RE: 9931 Lomas N.E.

REF: 9931 Lomas NE J20-D7

On April 26, 1983, a field survey was conducted to determine if the above mentioned site was in close compliance to the approved plan. Below you will find listed the items in variance to the approved plan:

DRAINAGE PLAN  
 10.10

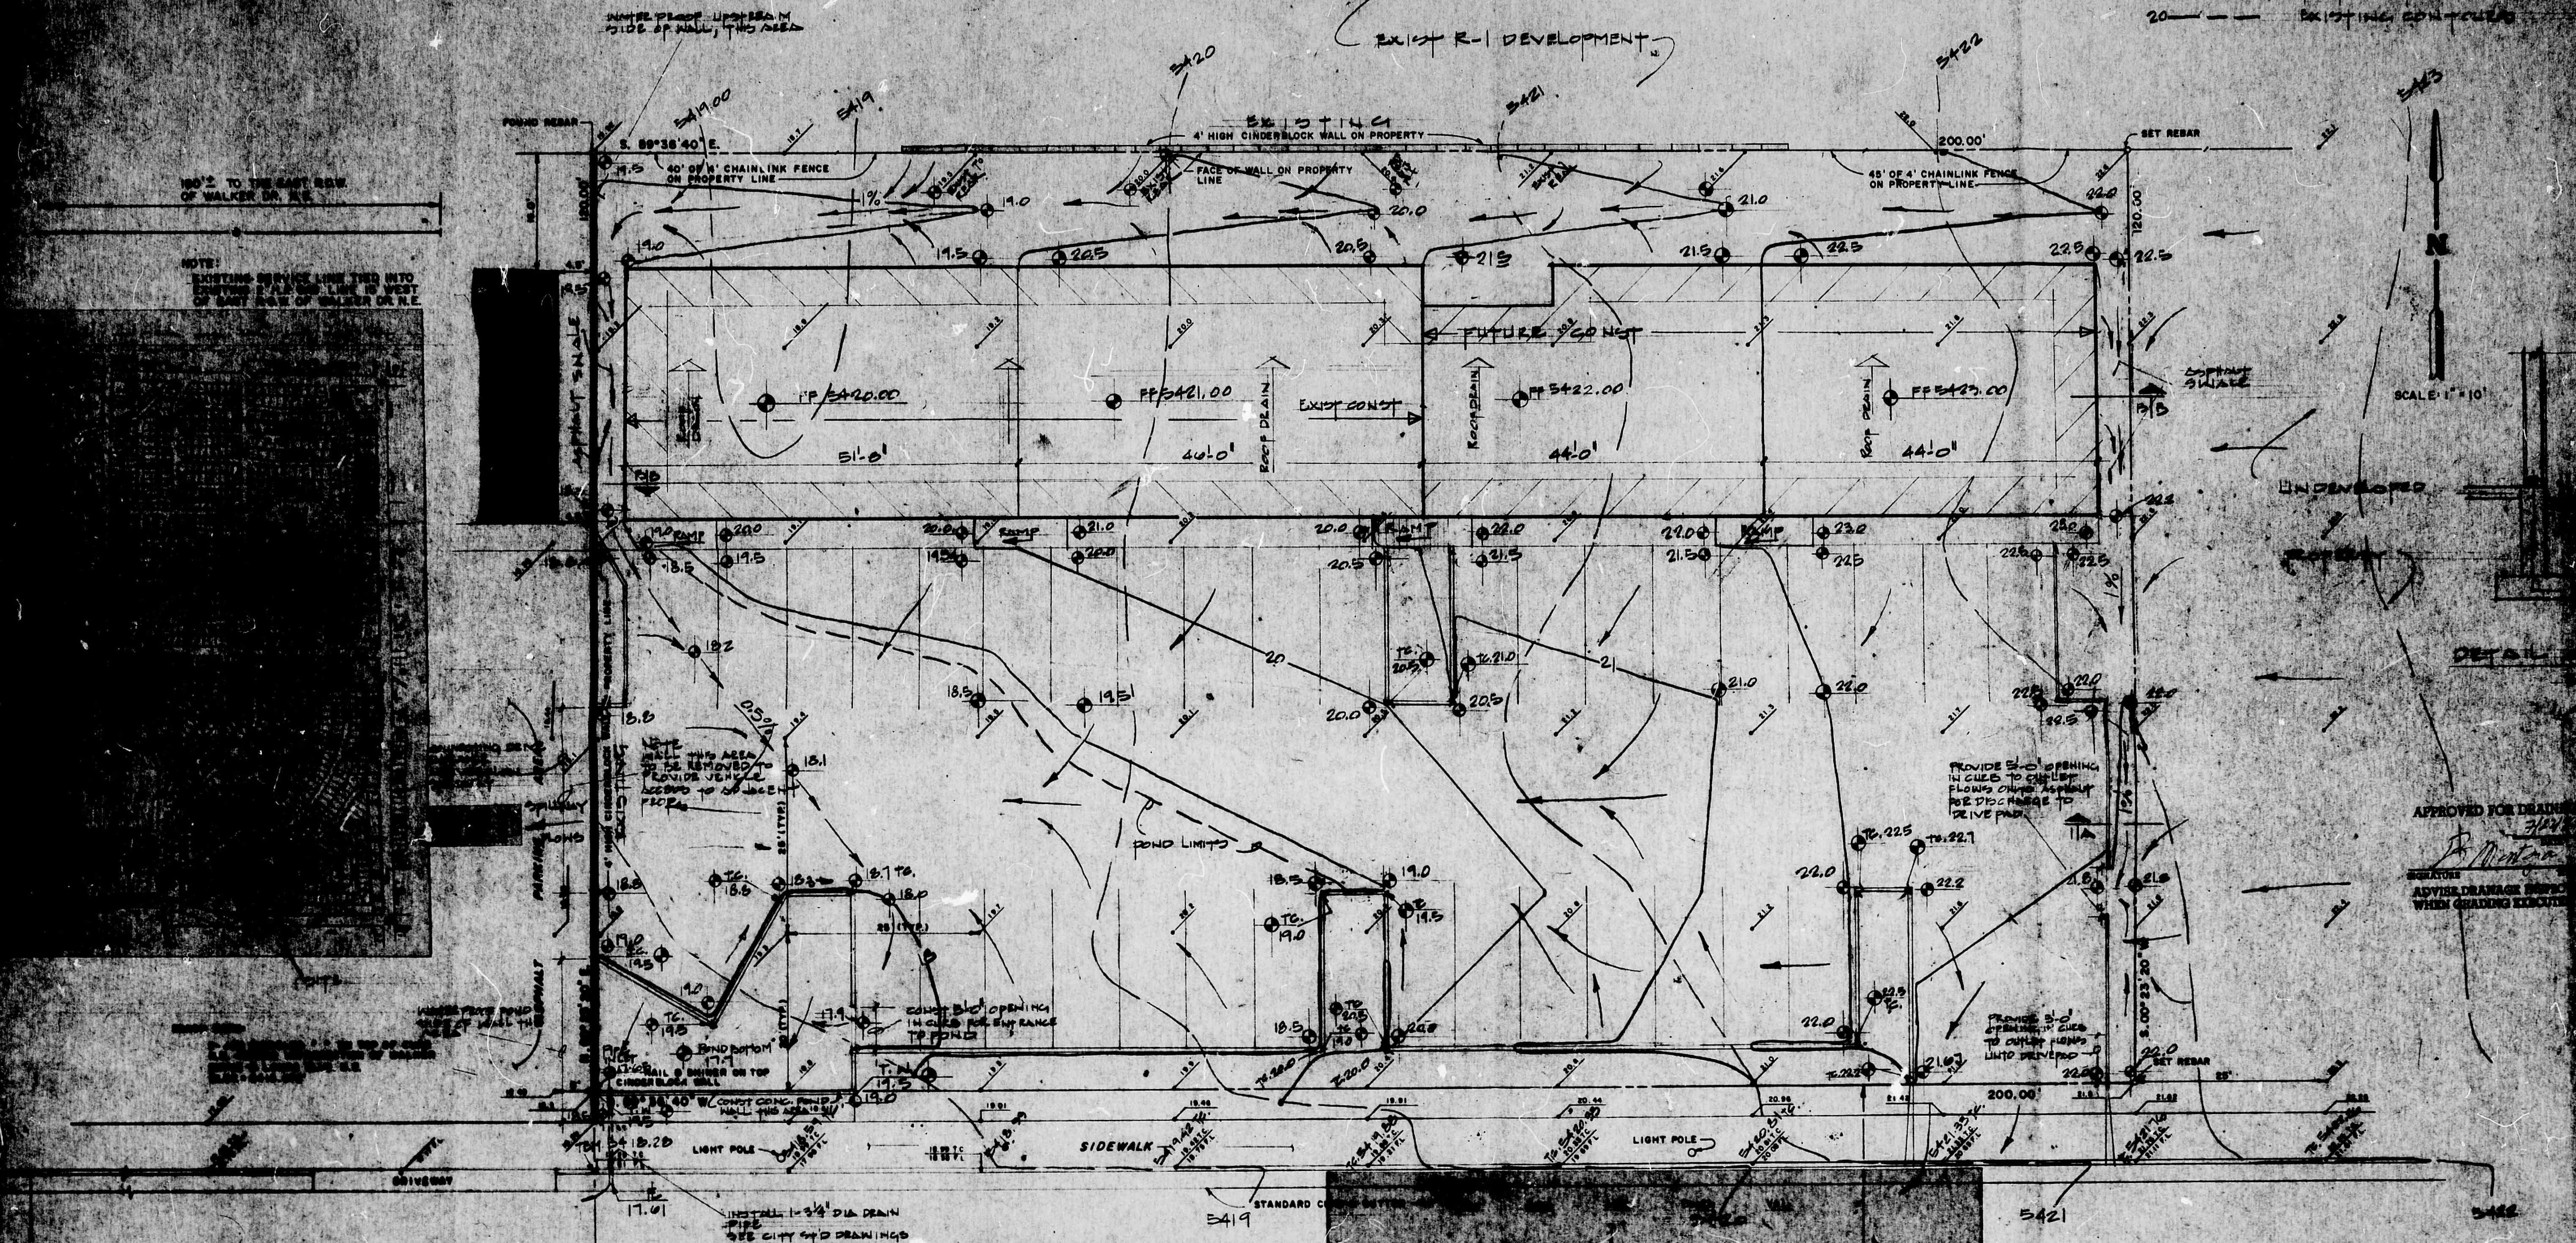
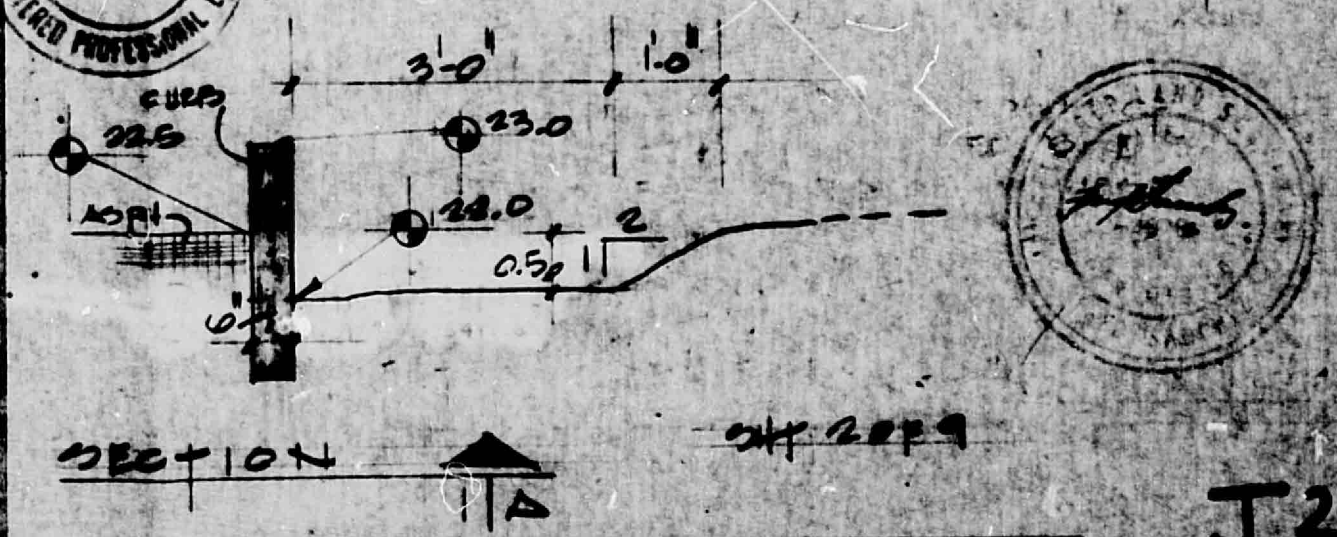
1. Total floor plan shown on plan not completed.
2. Concrete pond wall adjacent to sidewalk not constructed.
3. 4' high cinder block wall on North property line not constructed.
4. Northwest corner of 4' cinder block wall has to be reconstructed and water proofed.
5. 3' break on cinder wall from new construction to existing construction must be reconstructed so that no water from new construction enters existing site.
6. Pond walls not water proofed.

In order to get a clear picture as to what has been completed and what is proposed, an as-built plan will be required for review.
